# **KITITAS COUNTY**

## **DEPARTMENT OF PUBLIC WORKS**

TO: All Staff  
FROM: Public Works Plan Review Team  
DATE: October 4, 2021  
SUBJECT: BL-21-00022 Pass Life Origins

The Public Works Department has reviewed the Request for Boundary Line Adjustment Application.

| CHKD BY M.K.K./D.L.P. | SCALE 1" = 30' | SHEET 1 OF 5 |

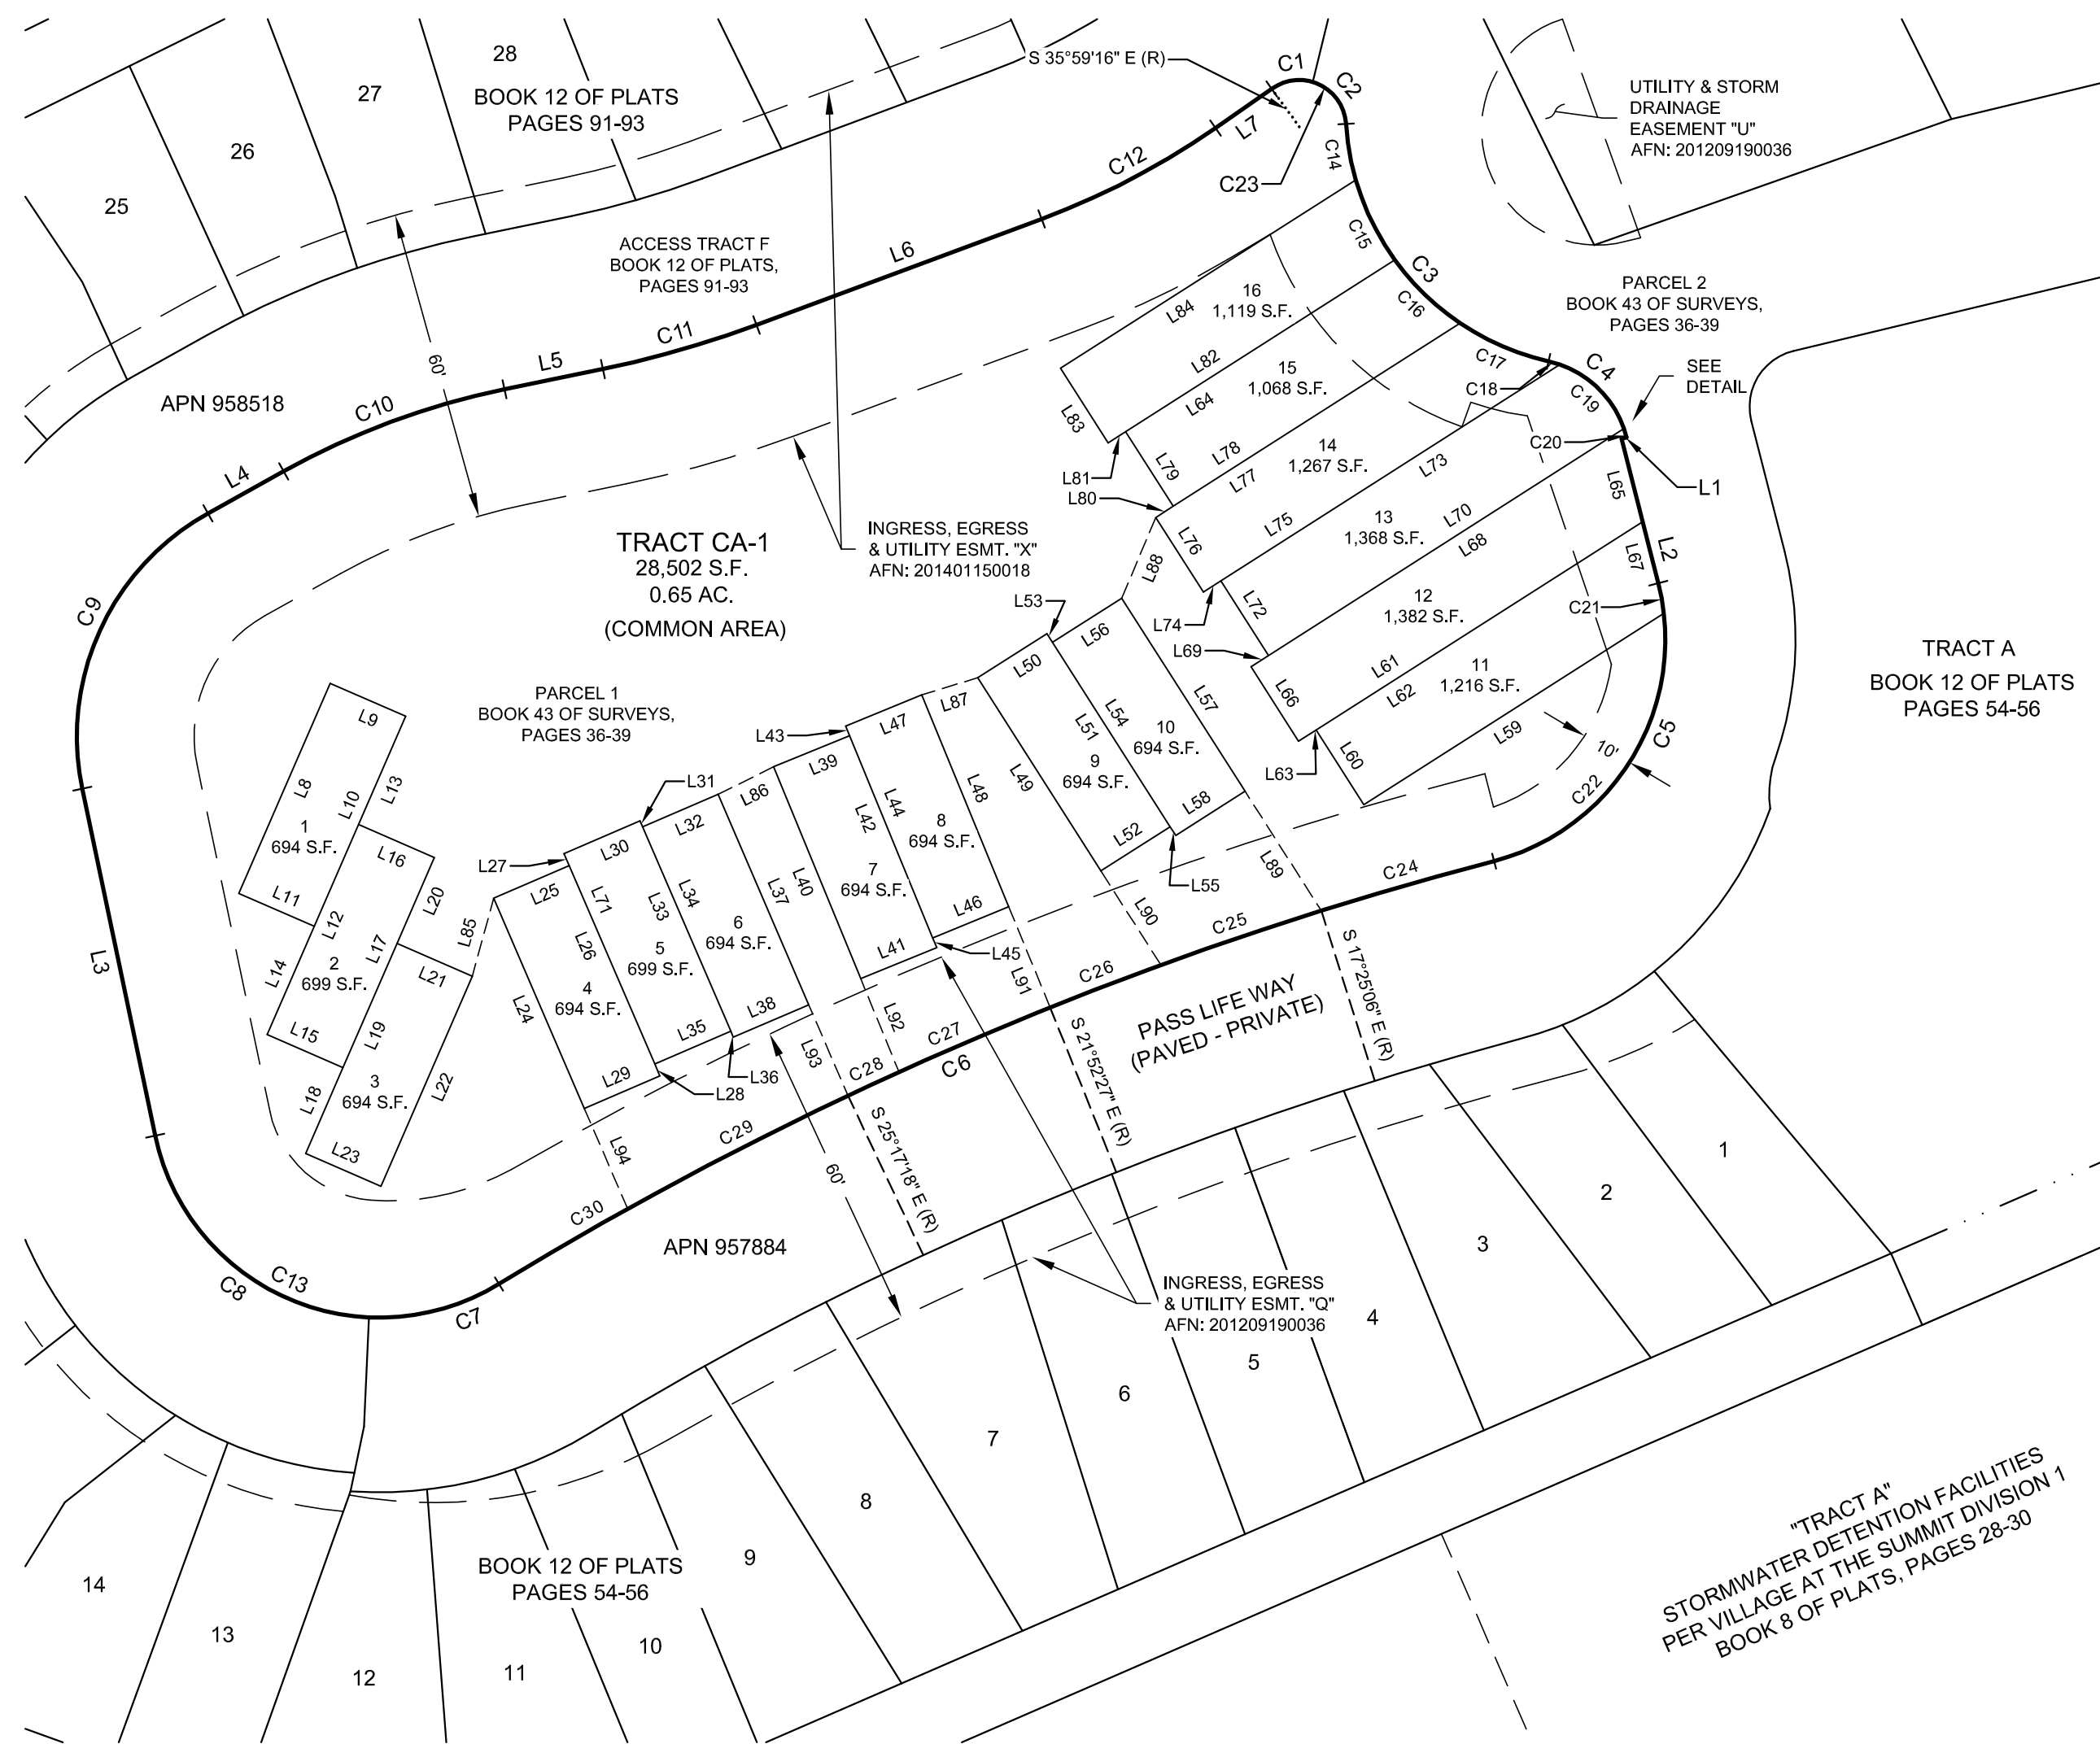
#### **Sheet 1**

1. Surveyor certificate, Auditor's certificate, basis of bearing, survey equipment statement, and purpose of survey will need to be included prior to final recording.
2. At minimum, the new division line shall be surveyed and staked in the field.
